From: Katie Kurek [REDACTED]
Sent: 04 December 2017 11:58
To: Simon Davis
Subject: RE: Planning Services Response Re-consultation EG/69/17

Further to your response below, we have a parish council objection stating: "The council considers that the application should not be permitted without an allocation of space, on site, for articulated and other vehicles to turn. A condition requiring the use of such turning space should, if possible, be added to any permission."

Fire Tender	7.334m
Overall Length	2.280m
Overall Width	3.495m
Overall Body Height	0.380m
Min Body Ground Clearance	2.280m
Track Width	5.00s
Lock-to-lock time	6.000m
Curb to Curb Turning Radius

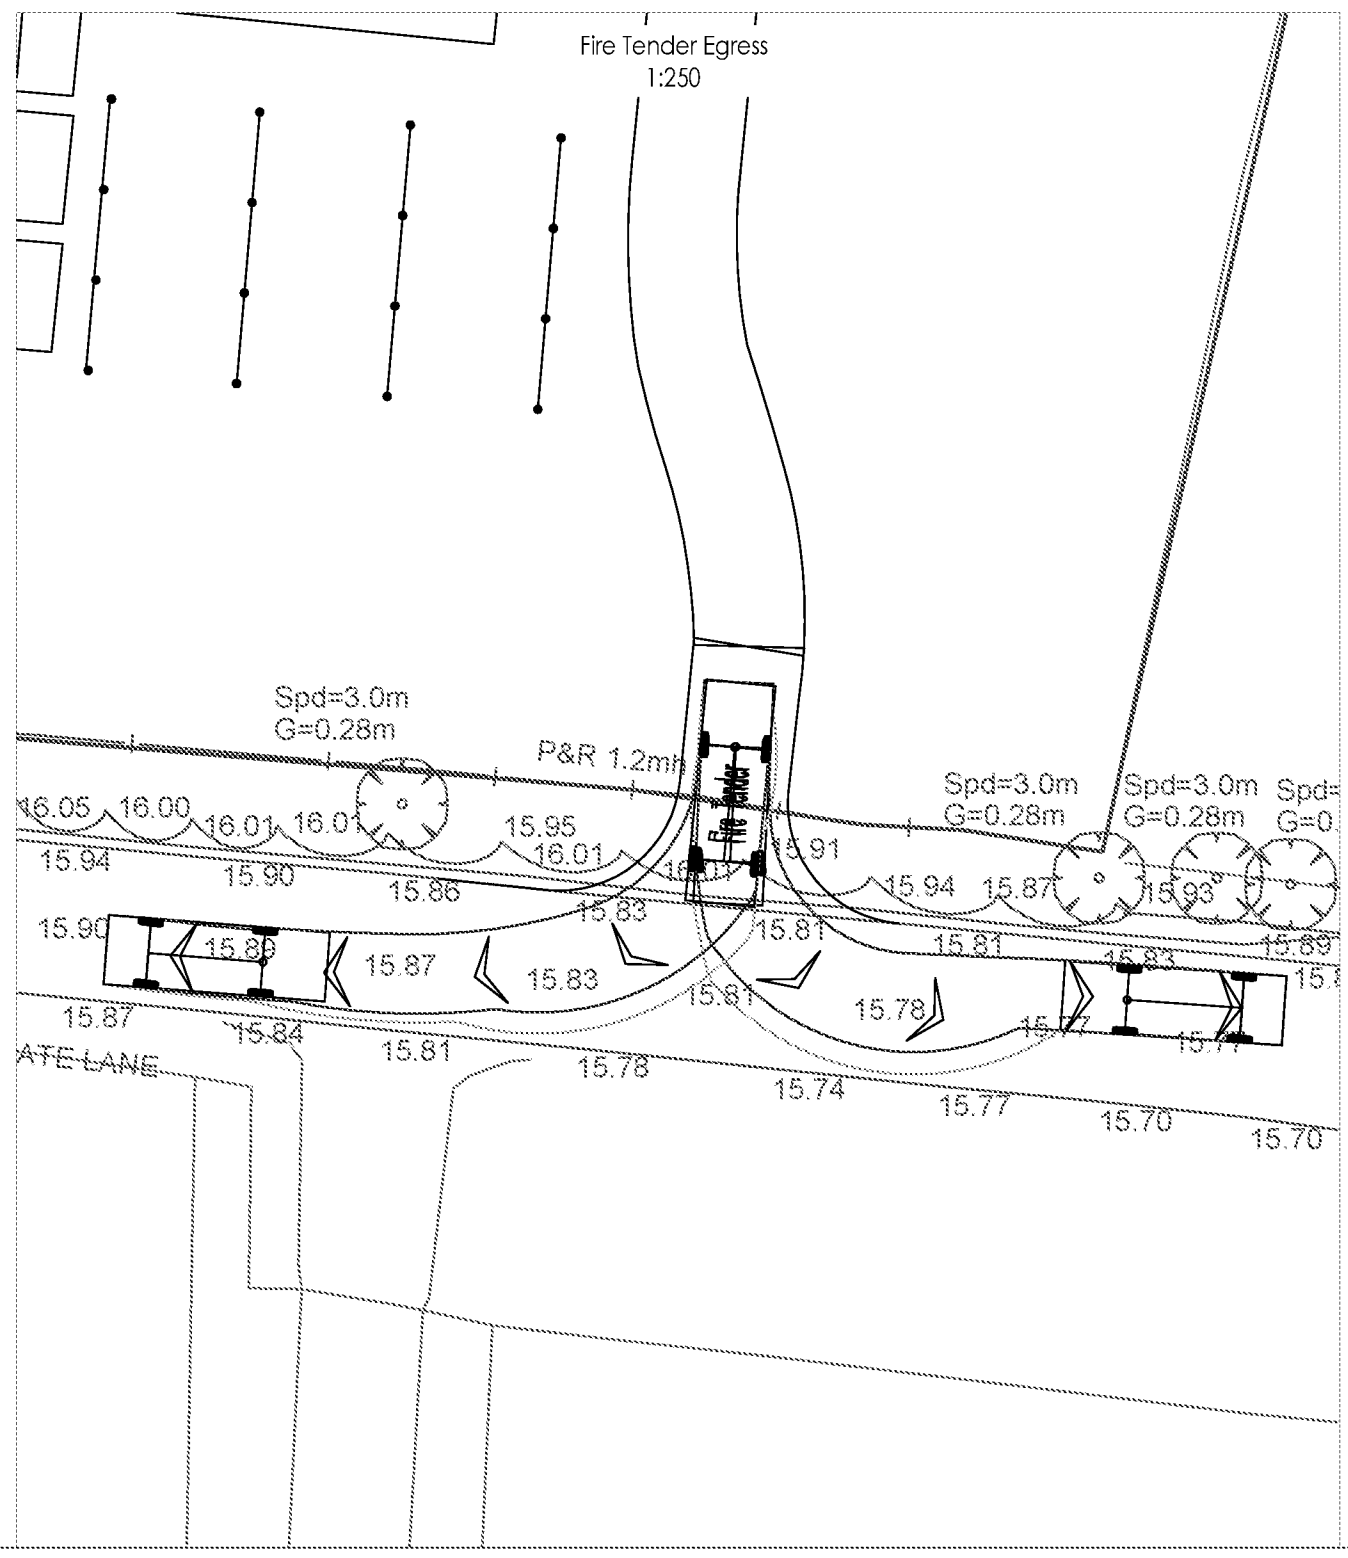
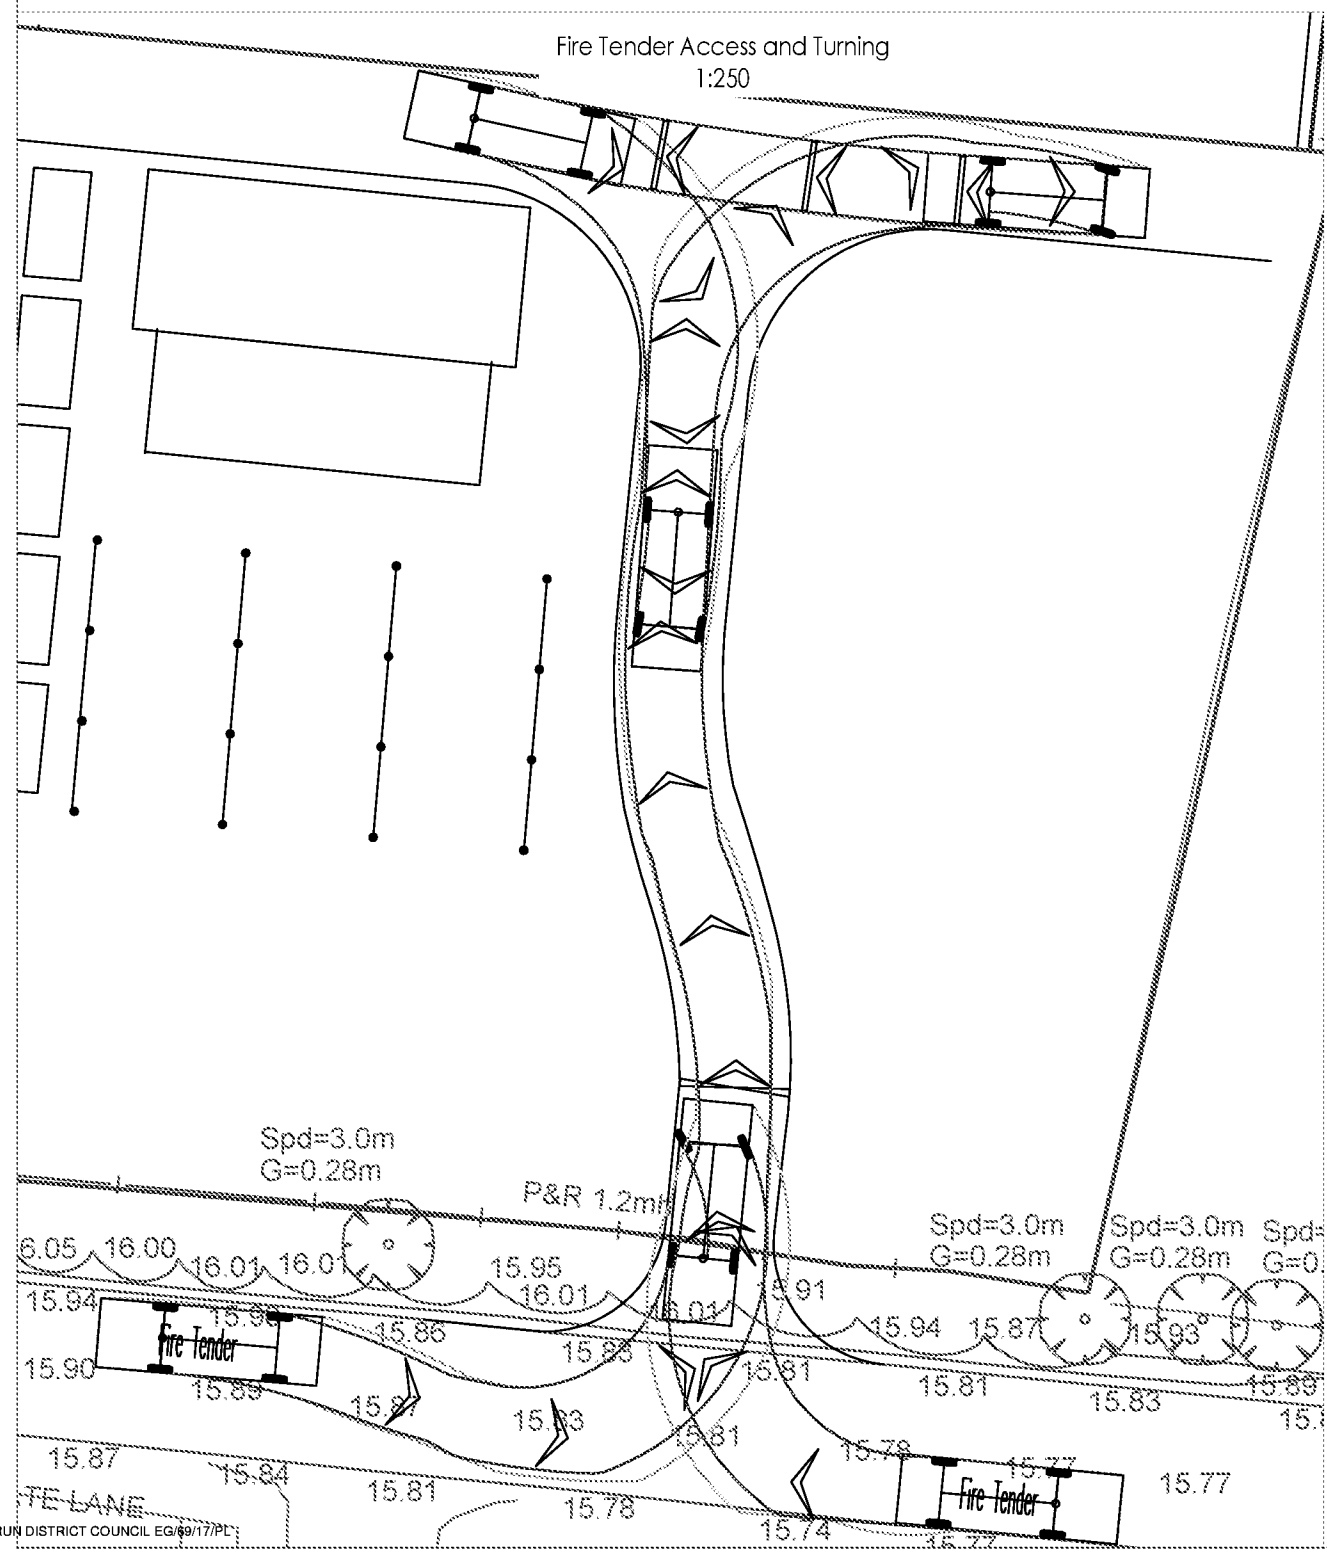
Using our own swept path plans I cannot be 100% sure that an articulated lorry could turn with the live/work unit section of the site because of the limitations of the drawings. However, I am mindful of the existing layout with the greenhouses and that with regard to space available to turn on site this does not appear to be materially different from existing situation. With reduction in greenhouse at the site and proposed use as live/ work light industrial units I would question the need for an articulated lorry to serve the site. It may be worth asking the applicant if and how this occurred on the site as existing and whether these type of vehicles are anticipated with the modified use at the site.

Your response states that the turning space on site would be suitable for larger vehicles including refuse collection and fire appliance. Would this include articulated vehicles?
